From: Simon Davis
Sent: 05 September 2025 16:56
To: 'Gabriella Chan' [REDACTED]
Cc: REMICT Info [REDACTED]
Subject: RE: LUY/141/25/PL 57 River Road Littlehampton

Further to the below, please see the attached Highways comments. They may not have seen the plan showing the tracking for parking space 1 but regardless they also ask for details ref parking spaces 2 and 3. Can you provide an amended plan to me, and I will then re-consult them.

North Arrow		North	
Project		47 River Rd, Littlehampton BN17 5BF	
Drawing Title		Drawing Number	
PROPOSED GROUND FLOOR PLAN		A_100	
Scale		Date	26/04/2024
Status		Revision	P_01
PLANNING

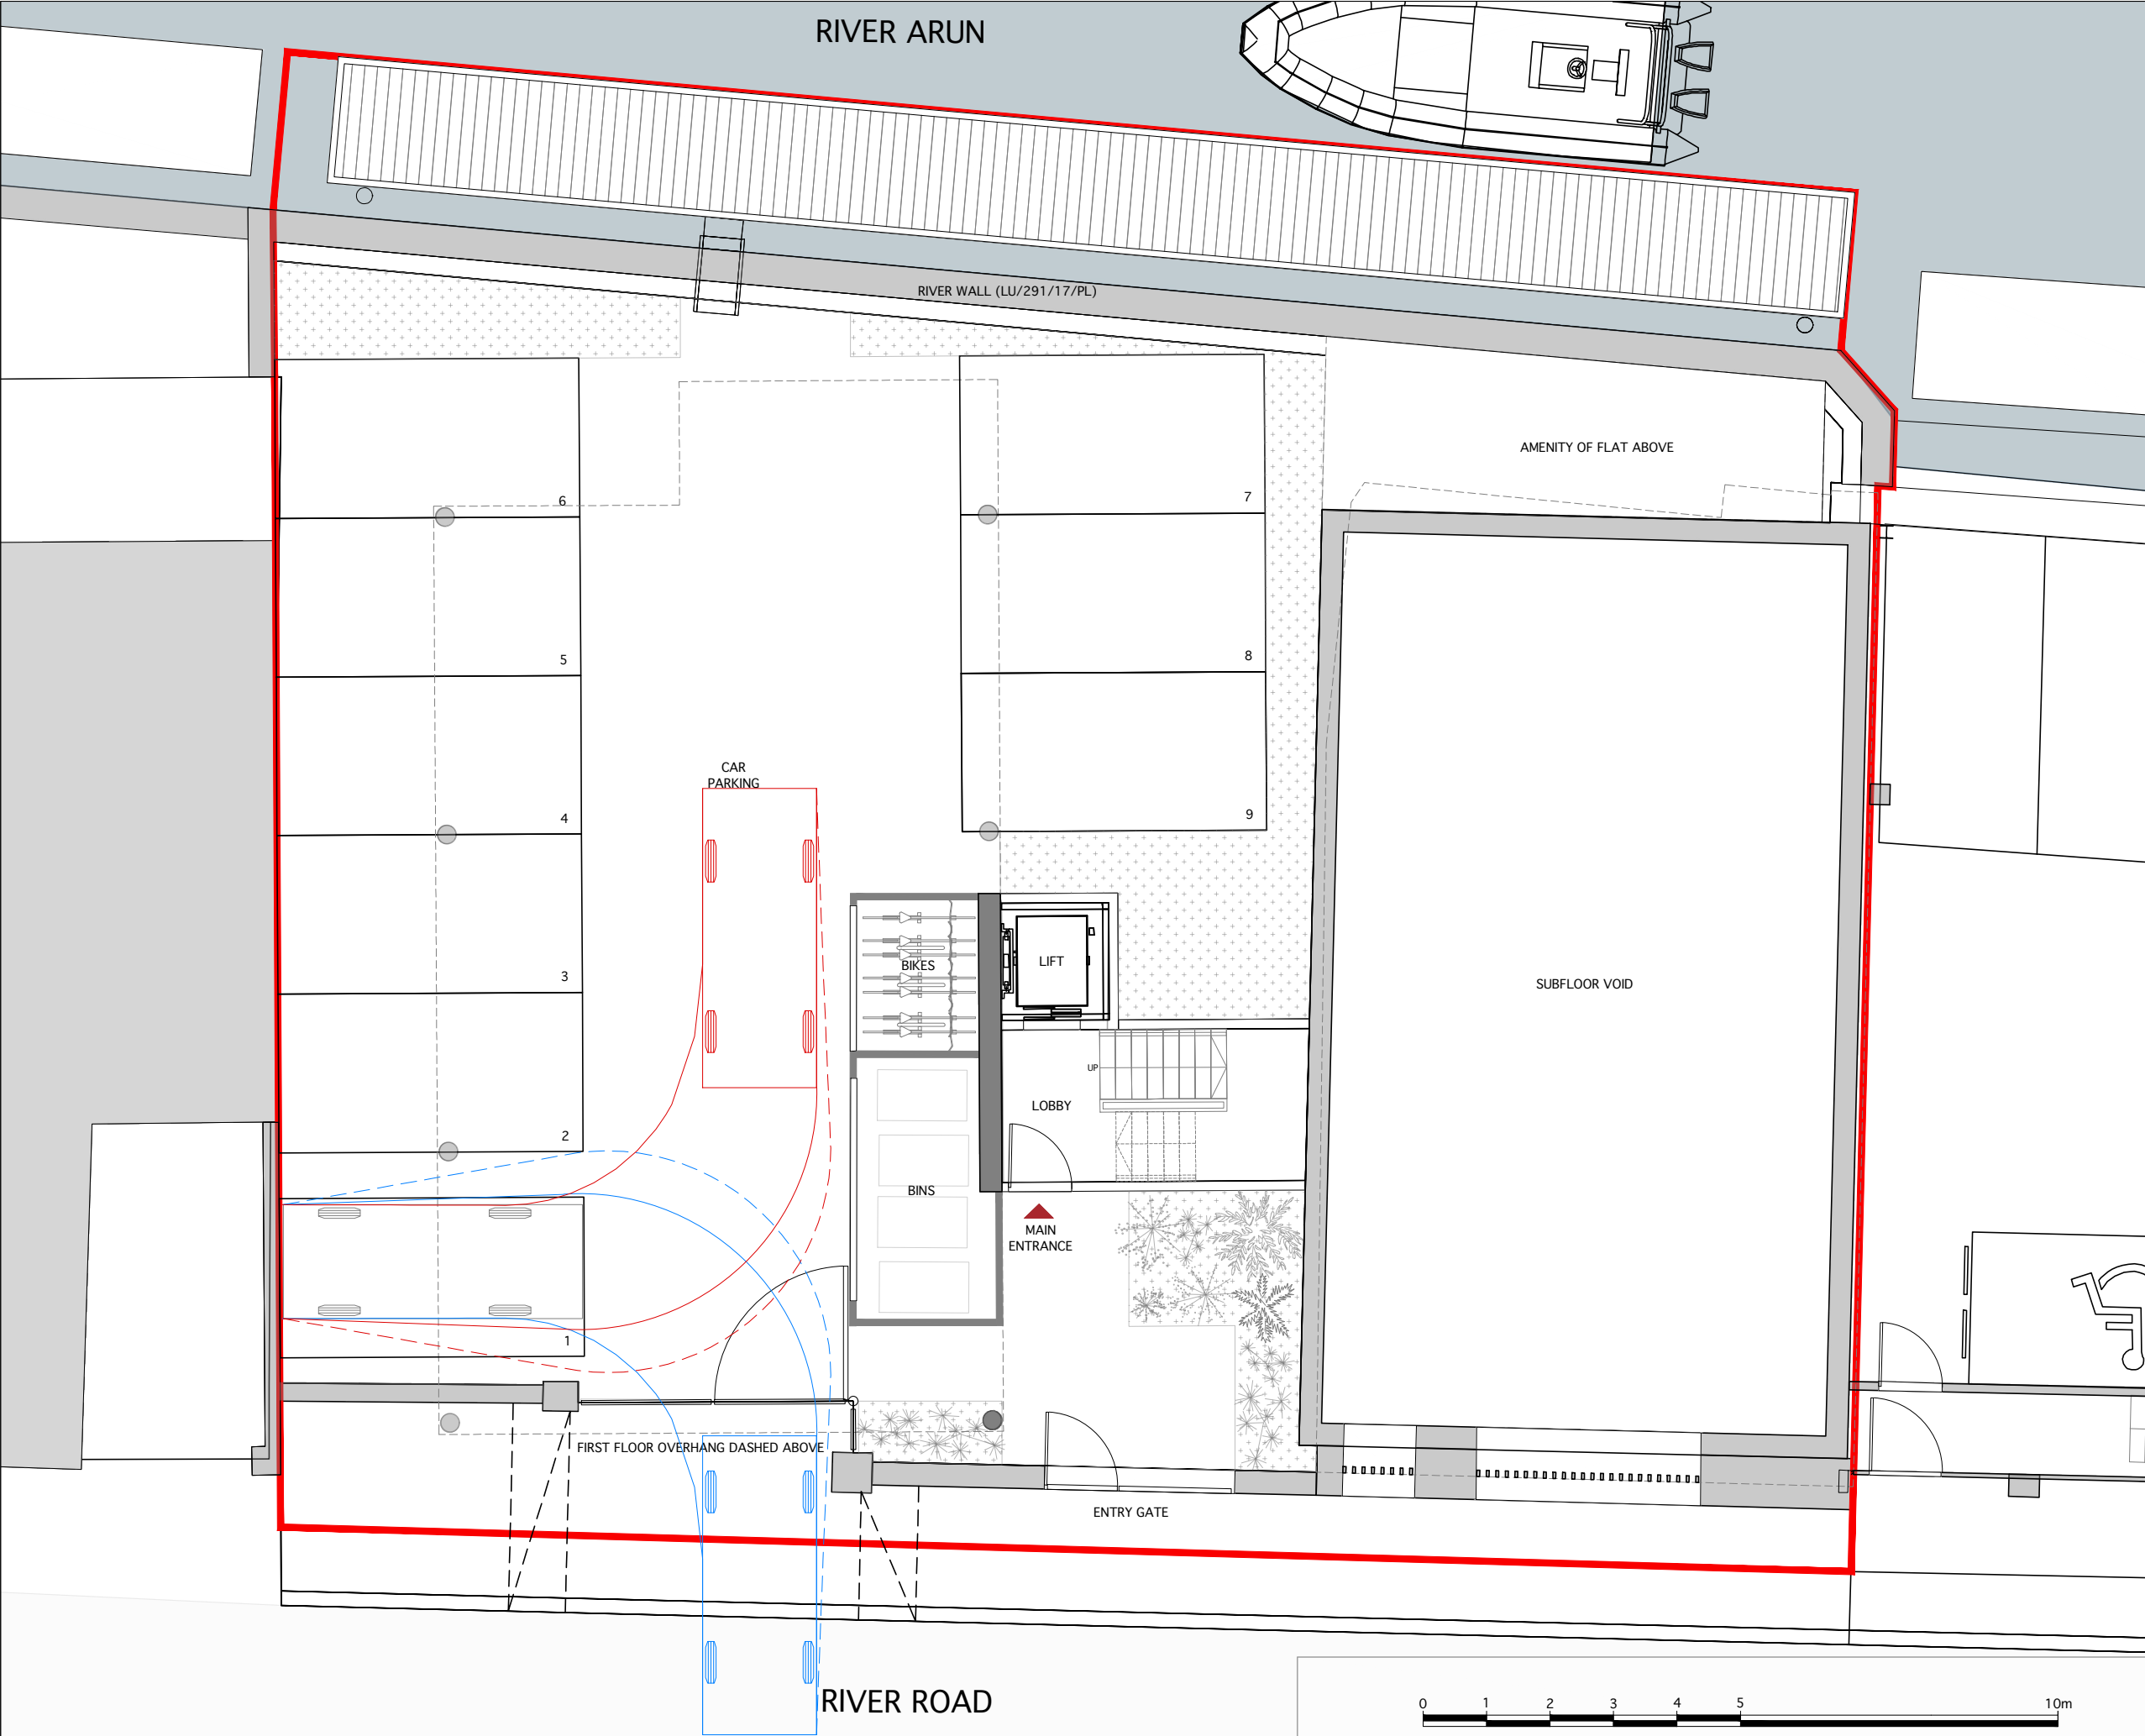
I write to ask whether you can arrange for some tracking drawings to demonstrate how cars will enter and exit parking space 1 (by the entrance) in a forward gear.

RESPONSE: Please see the attached revised drawing A_100, which includes tracking for Parking Space 1 as requested. The swept-path analysis illustrates a standard vehicle (refer to the notes column for details) entering and exiting Parking Space 1 in forward motion. We trust that these diagrams will satisfy the requirement.
